From: Richard Castro-Parker
Sent: 23 September 2019 12:19
To: Laura Gibbons
Cc: Juan Baeza; Samantha Lee
Subject: FW: BE/139/18/PL - Innovation Centre Beeding Close

Richard Castro-Parker
Senior Planning Officer (Contract)
Arun District Council

Laura Gibbons, MEng, GMICE
Engineer (Drainage & Coastal)

Key

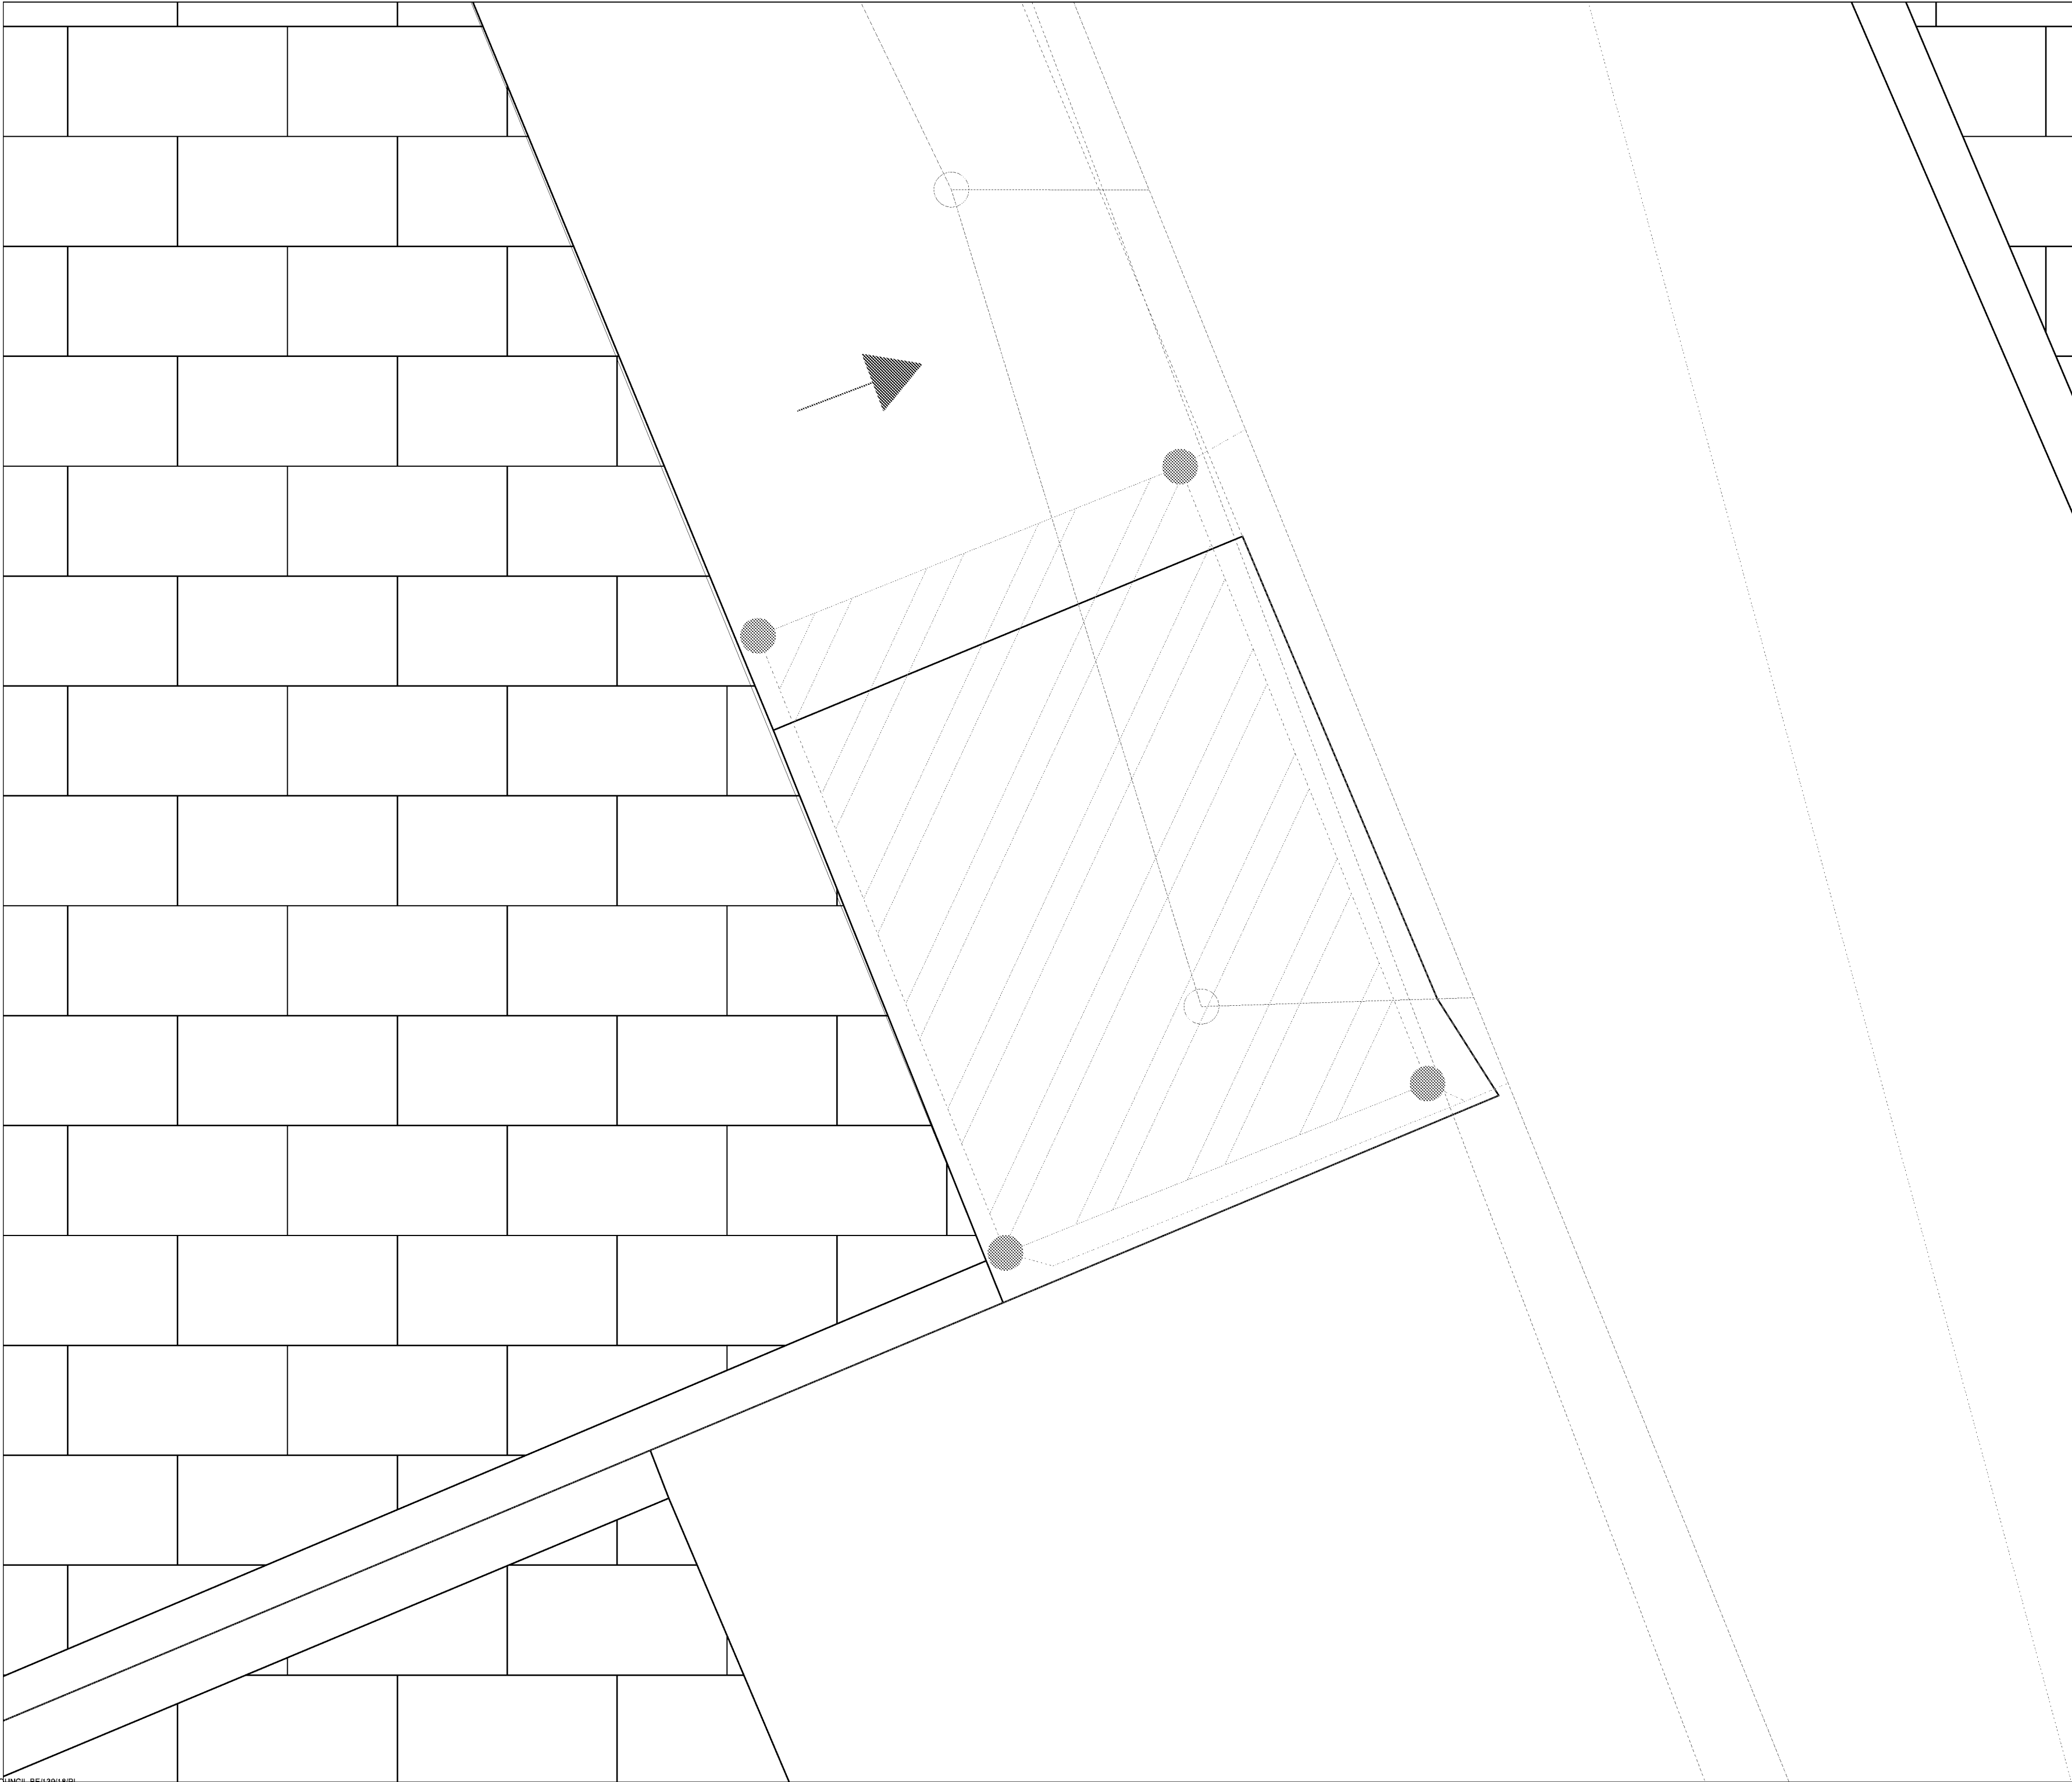
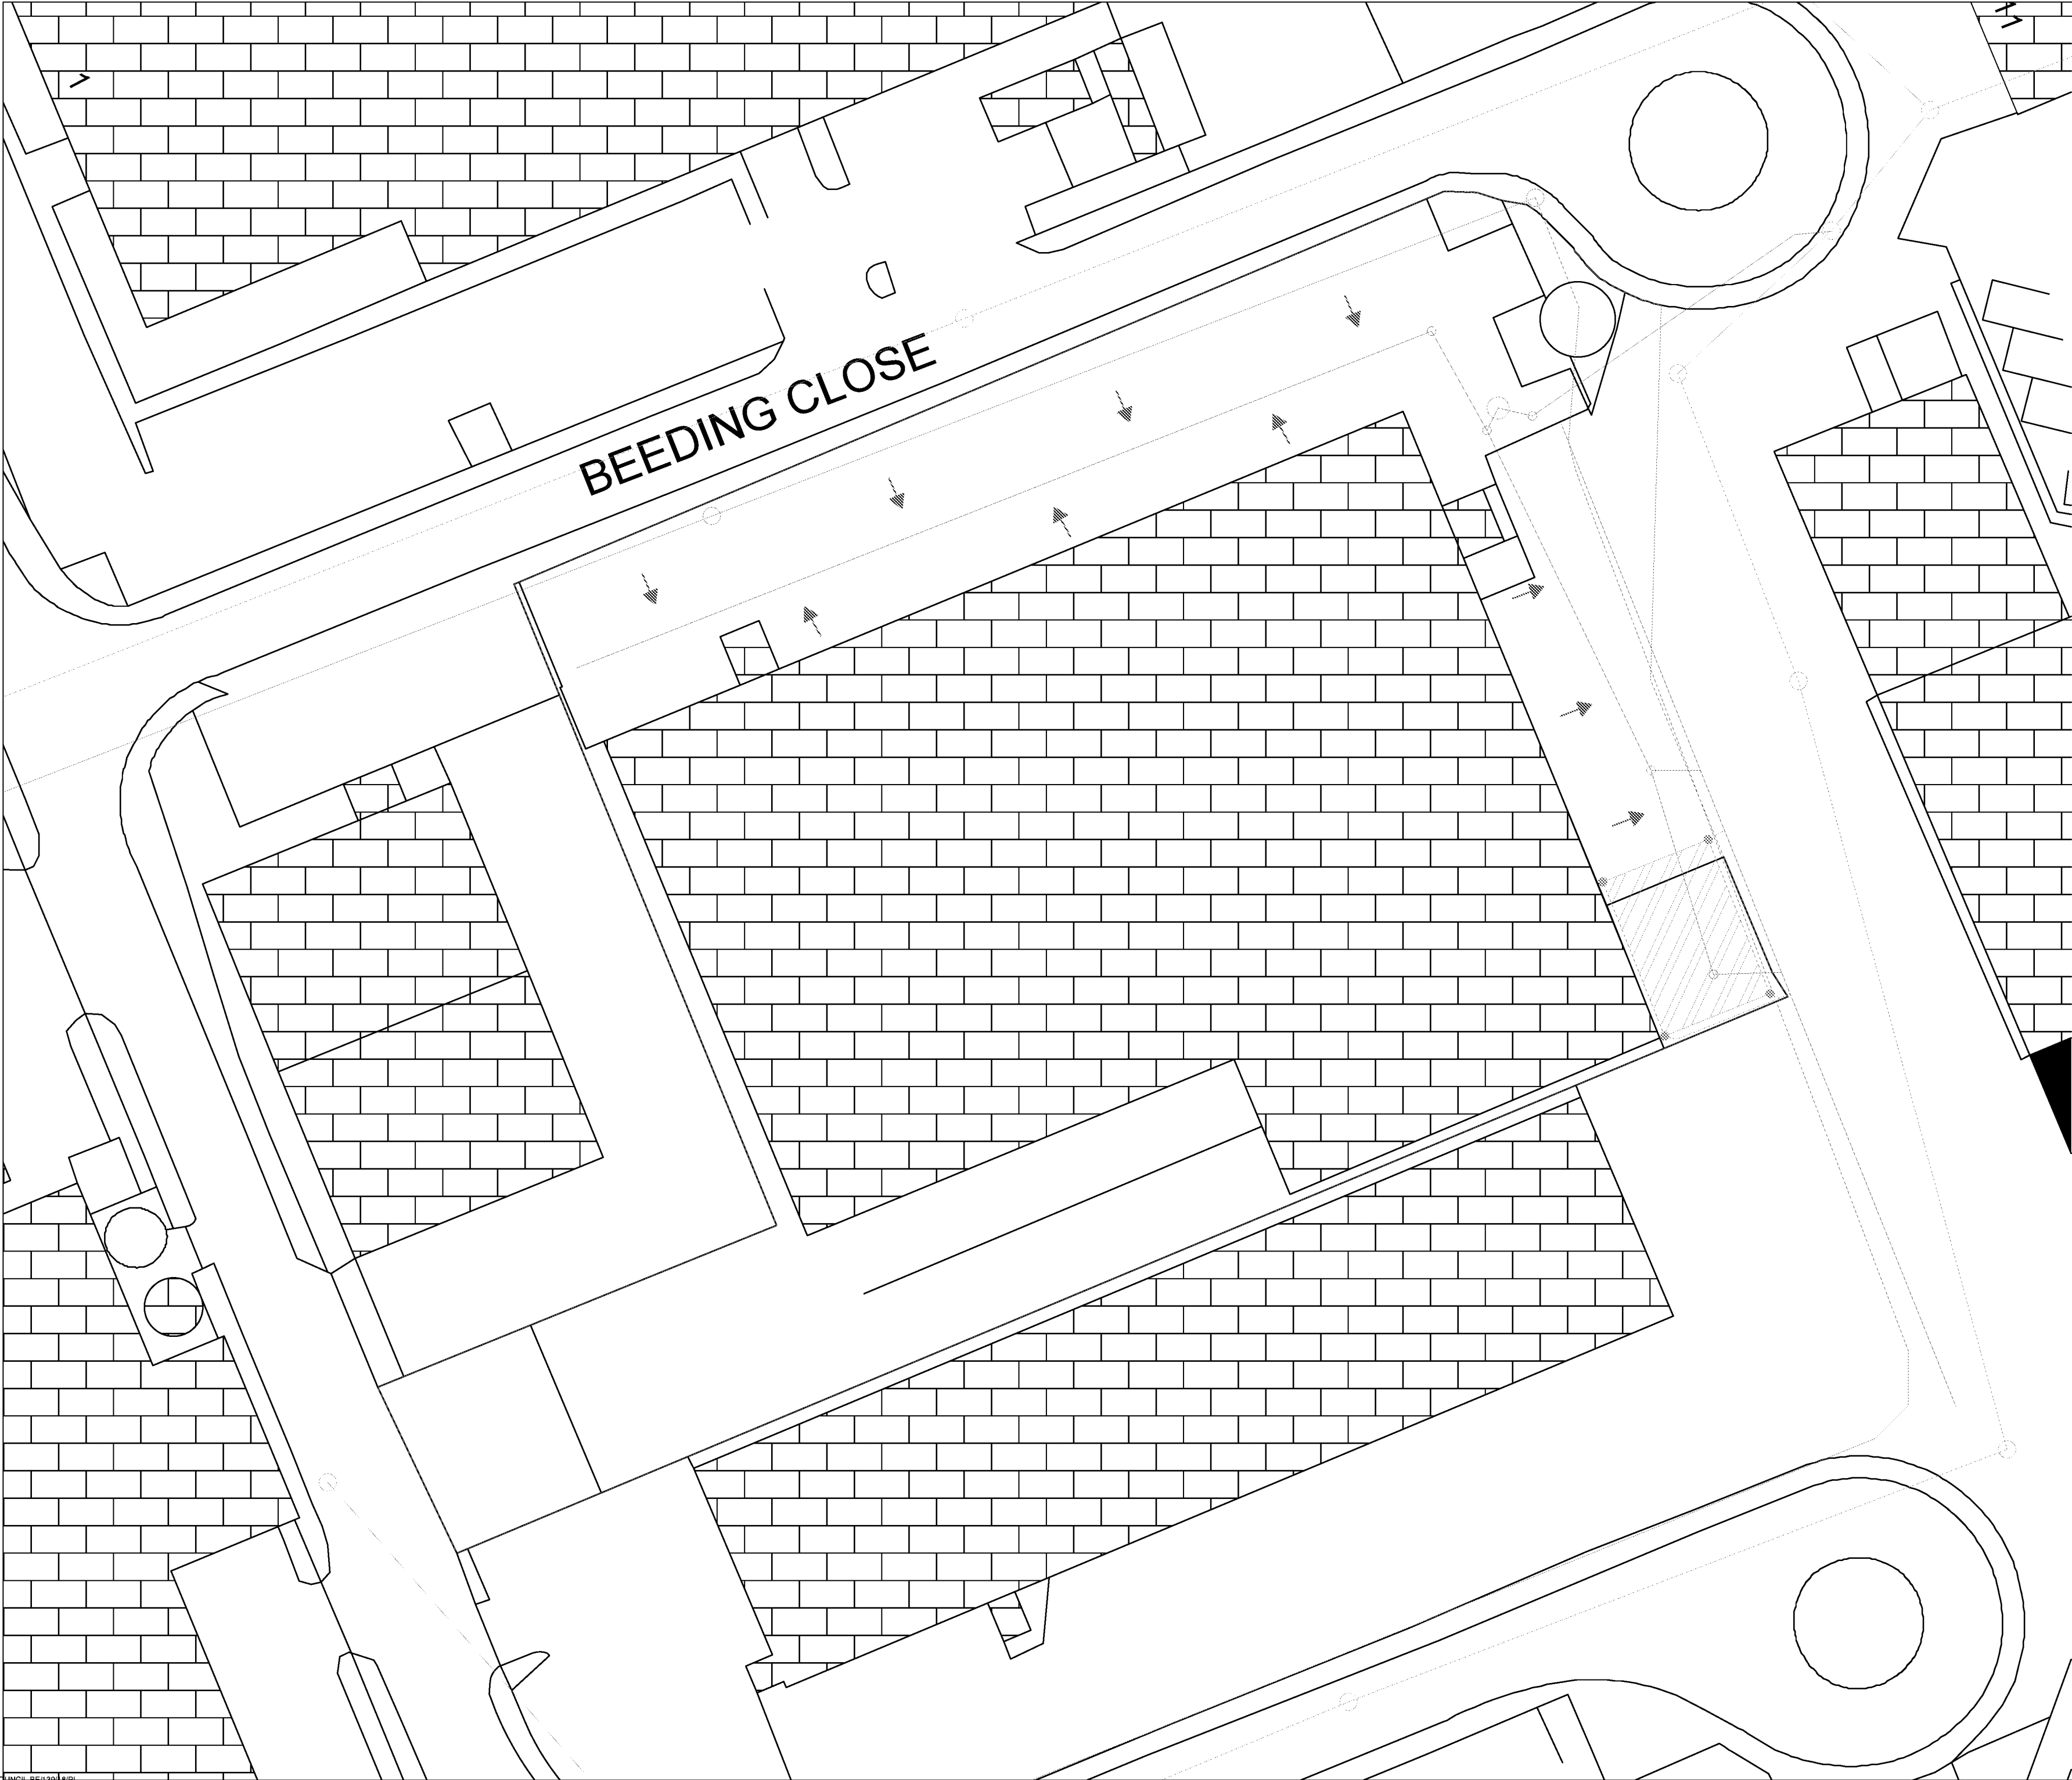
I still am struggling to distinguish between lines. Please can different line types be used, rather than all very similar colours. Please can gullies, manholes, and linear drainage channels be clearly labelled.

Regarding the levels, I also requested some spot levels of the surrounding land, can these be provided. This is fundamental to ensure that the surface water from the development does not go off site.

Please can the applicant submit clearer plans of the proposed surface water drainage arrangement. I.e. different line types used, rather than all very similar colours. Please can gullies, manholes, and linear drainage channels be clearly labelled.

I also require levels to be submitted showing invert and cover levels of the existing drainage network and spot levels of the surrounding land. This is fundamental to ensure that the surface water from the development does not go off site.

Please find attached a PDF of the drainage layout plan for the site. Given the size of the site, all lines on the plans are small. However, if Laura zooms in she will be able to distinguish between the pipes types. This should hopefully address her first concern.

With regards to levels, having reviewed the sewer asset location search requested from Southern Water, both invert and cover levels for all Southern Water manholes are detailed within their response. A copy of the sewer asset location search was included within the appendix of the Surface Water Drainage Strategy – this have been attached to this email for her reference.
